re: Geotechnical Review
Proposed Parking Garage Access Ramp
56 Steacie Drive - Ottawa
to: Merkburn Holdings Ltd - Mr. Peter Dooher - pdooher@merkburn.com
date: June 12, 2019
file: PG4484-MEMO.02

- ☐ Project No. 18M-01672-00 - Drawing No. C-02 - Servicing Plan - Revision 2 dated April 3, 2019

- ALL WATERMANS TO BE PVC DR 18, WITH MINIMUM COVER OF 2.4m AND INSTALLED PER CITY OF OTTAWA STANDARDS.
- THRUST BLOCKS TO BE INSTALLED AT ALL BENDS, TEES, AND CAPS ALL AS PER OPSD 1103.01 AND 1103.02.

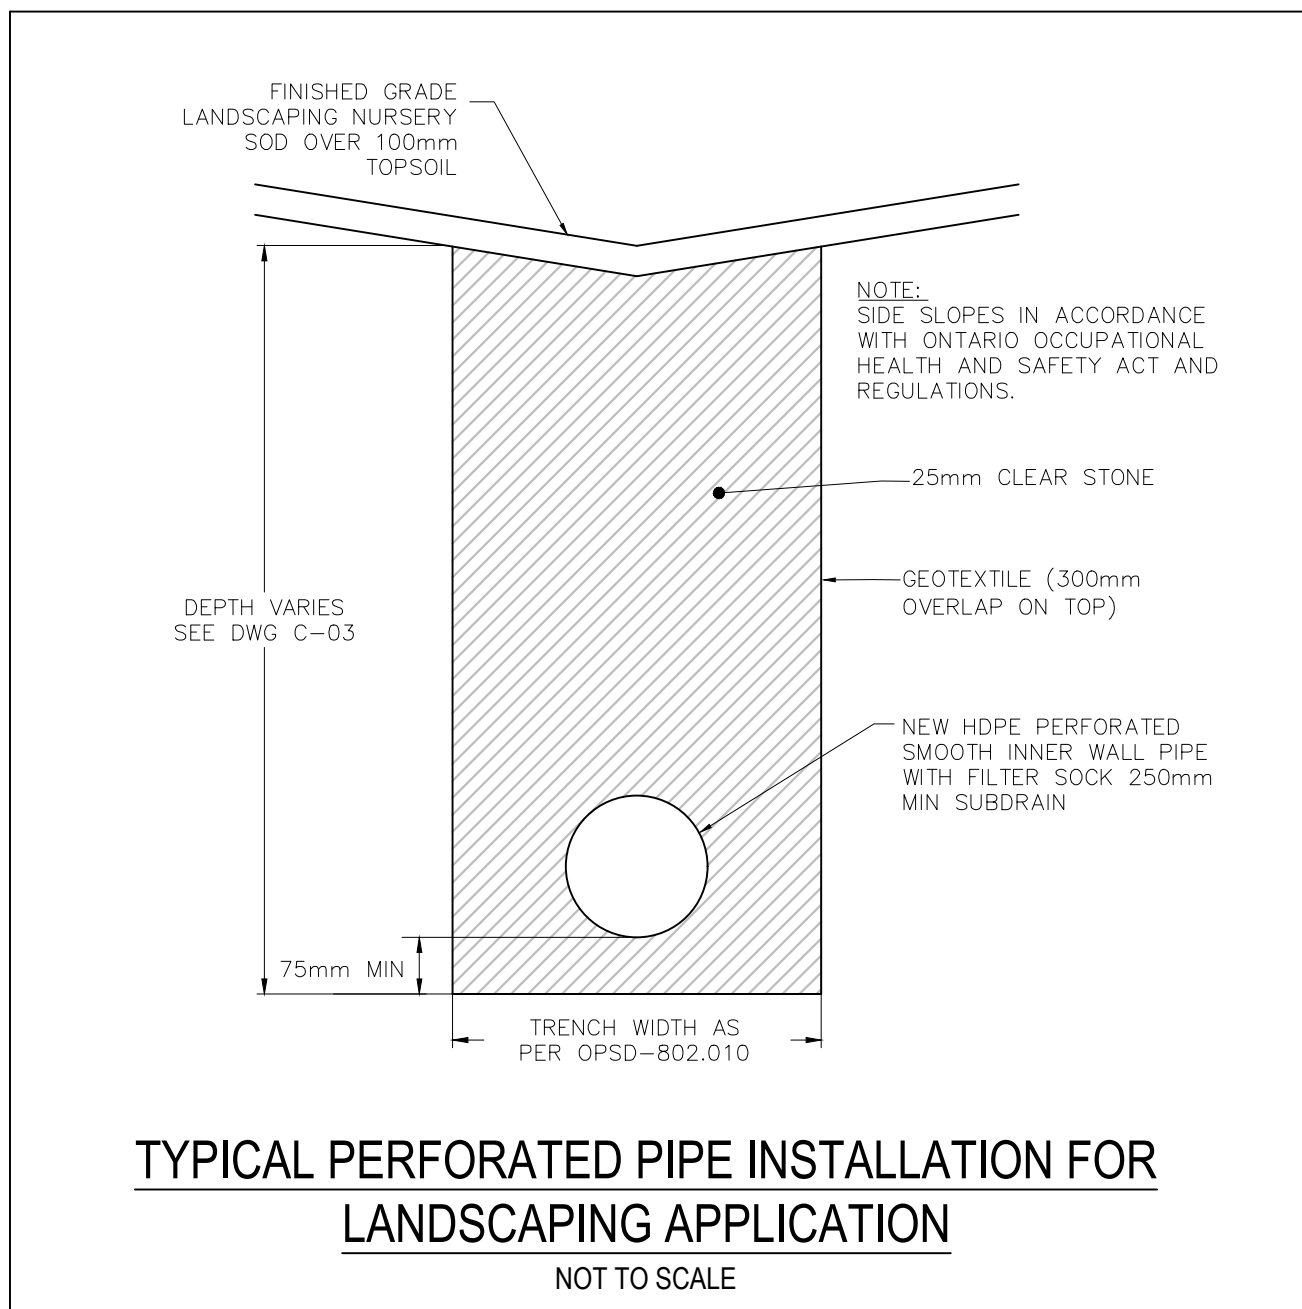
Section A on the above noted drawing shows a cross-section detail at a catch basin with an outlet to the proposed 375 mm diameter storm sewer. Based on the Section A detail, the total available frost cover above the outlet pipe is 521 mm, including the proposed 200 mm thick concrete pavement. In order to ensure adequate frost protection, it is understood that heat tracing will be provided within the concrete slab. It is further understood that the proposed outlet pipe will be wrapped with insulation resulting in a reduction of the granular material thickness for the pavement structure to approximately 270 mm below the concrete slab.

Based on our review of the above noted detail, the localized reduction in pavement structure granular thickness is considered acceptable from a geotechnical perspective.
